AND IN THE MATTER OF THE SIZEWELL C PROJECT BY SZC

AND IN THE MATTER OF THE NATIONAL FARMERS UNION AND
THE LAND INTEREST GROUP

WRITTEN REPRESENTATIONS

DRAWING TITLE:
 SIZEWELL LINK ROAD
 WATERCOURSE CROSSING LOCATIONS

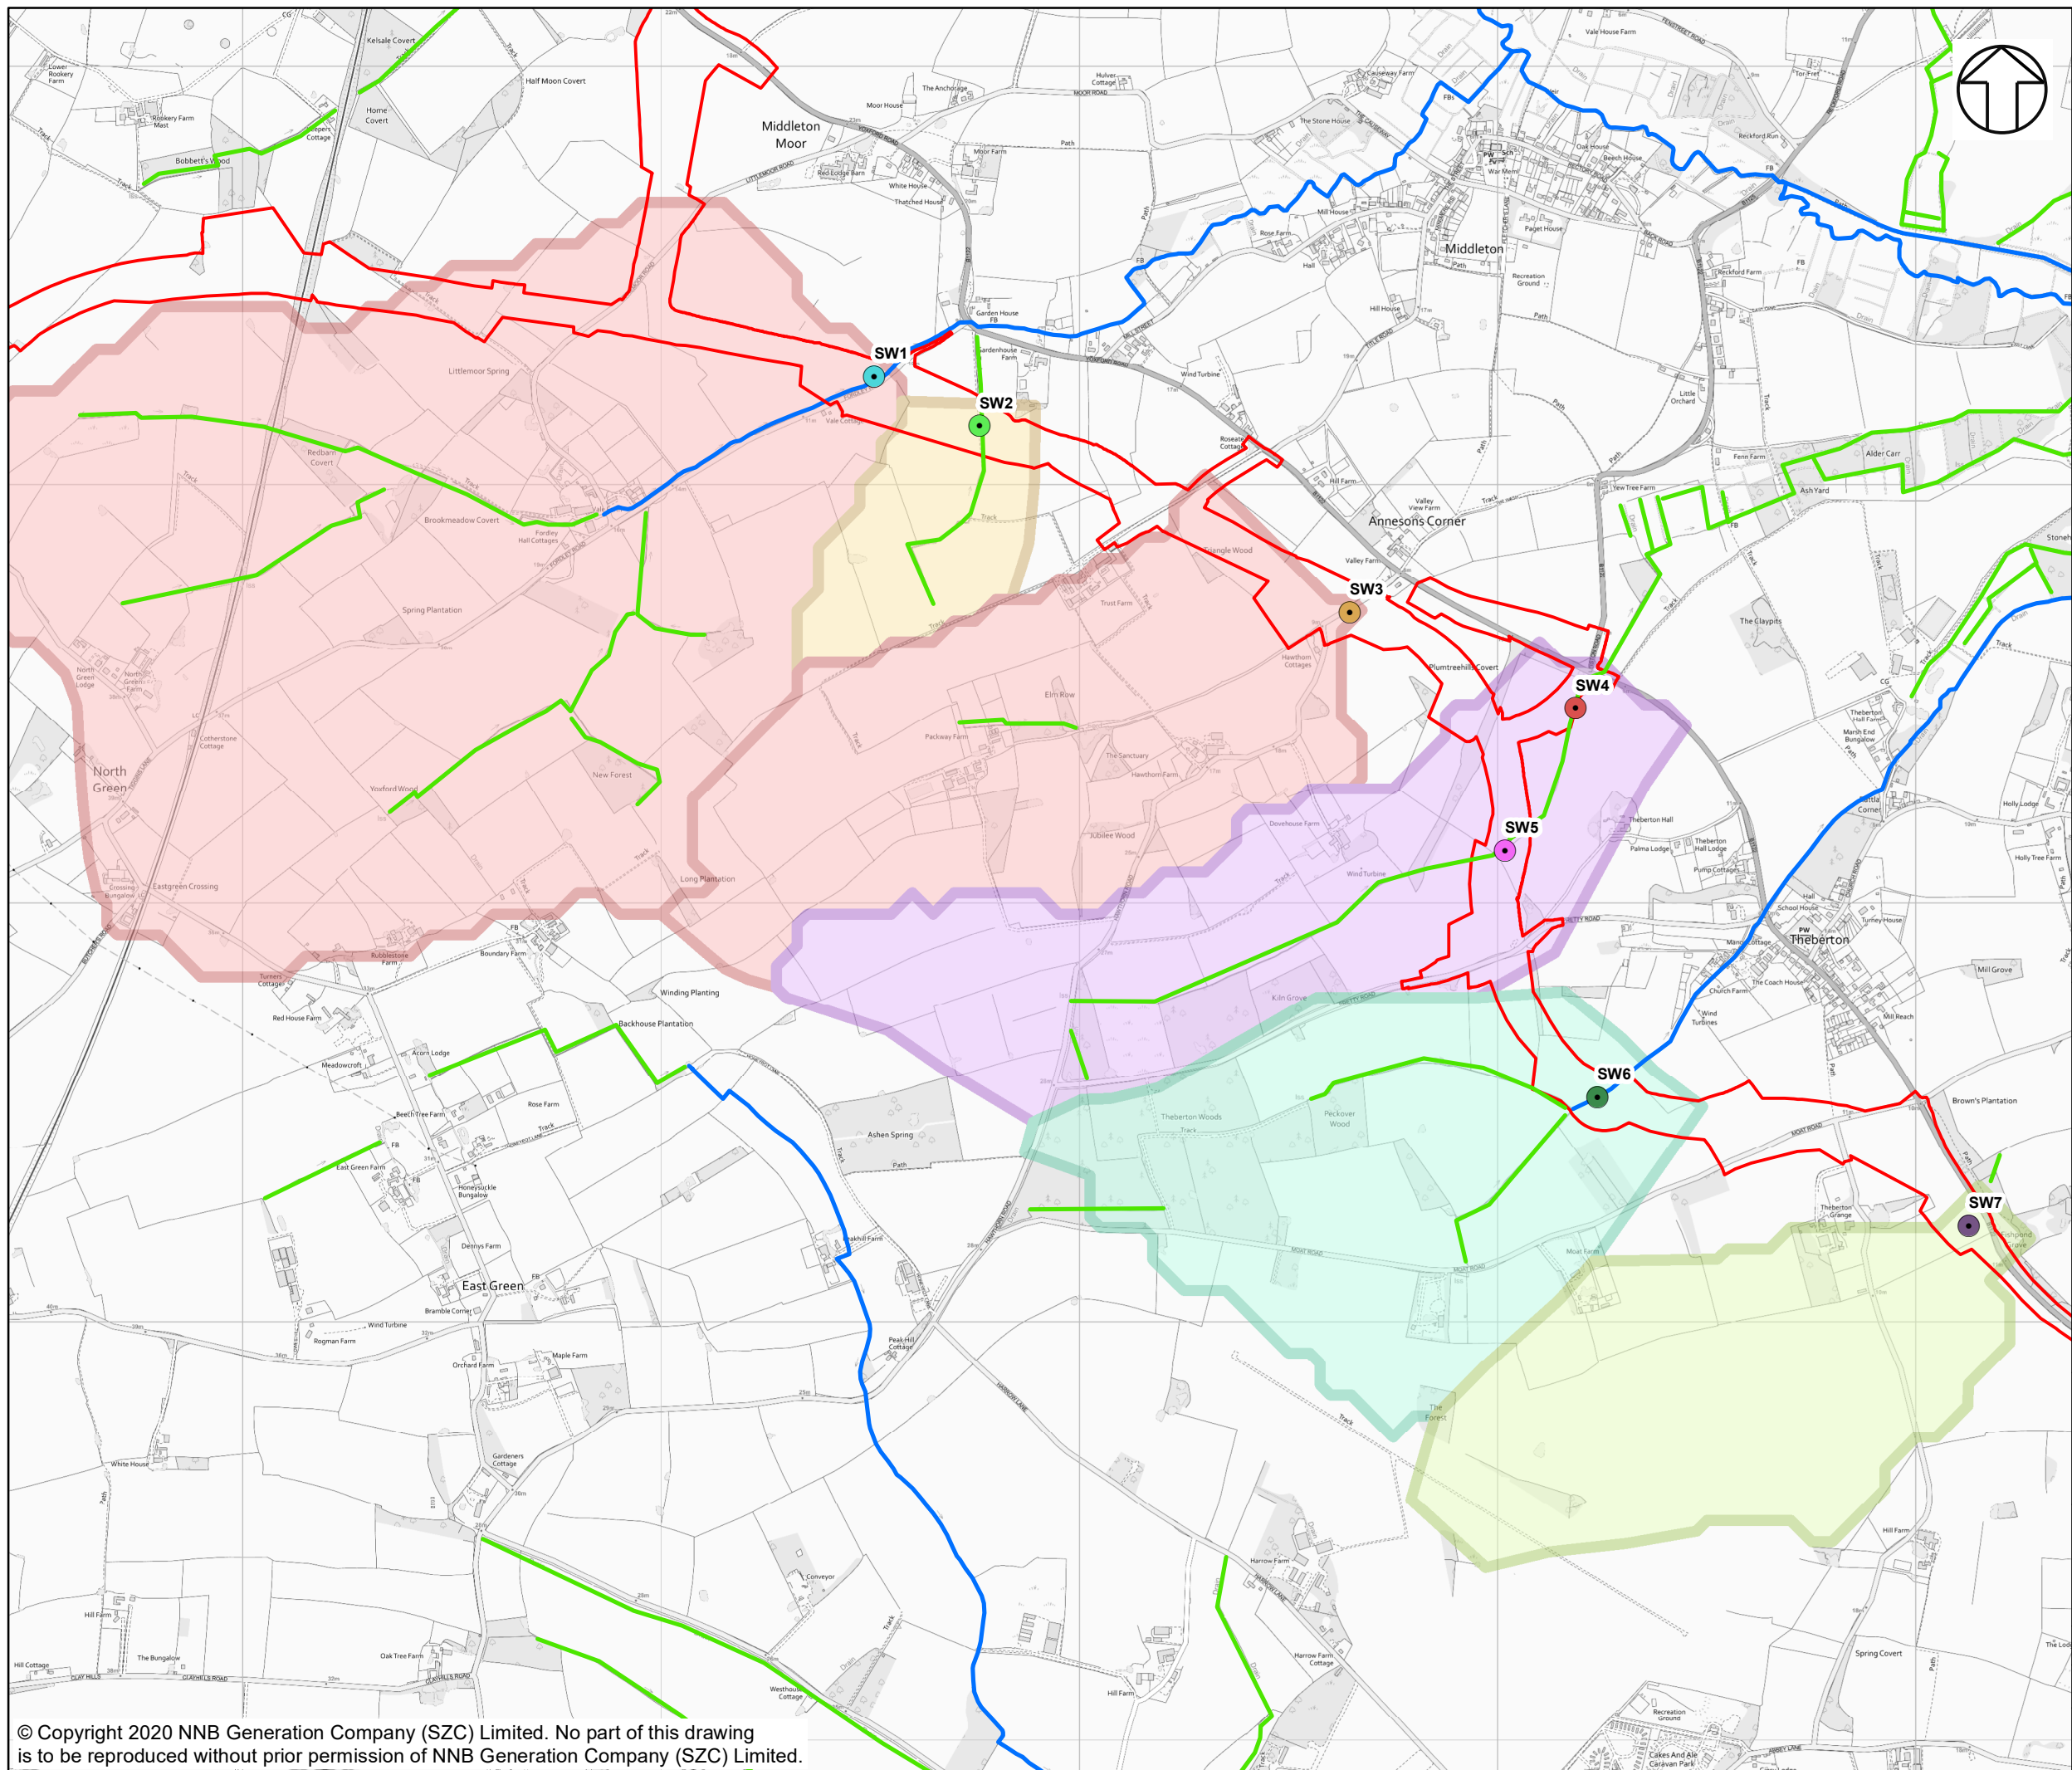
11.1 No details have been provided to landowners and occupiers on how any increase in surface run off of water from the new road, the haul road or the construction compounds will be dealt with during construction. Therefore there is concern that retained land may flood during the construction works.
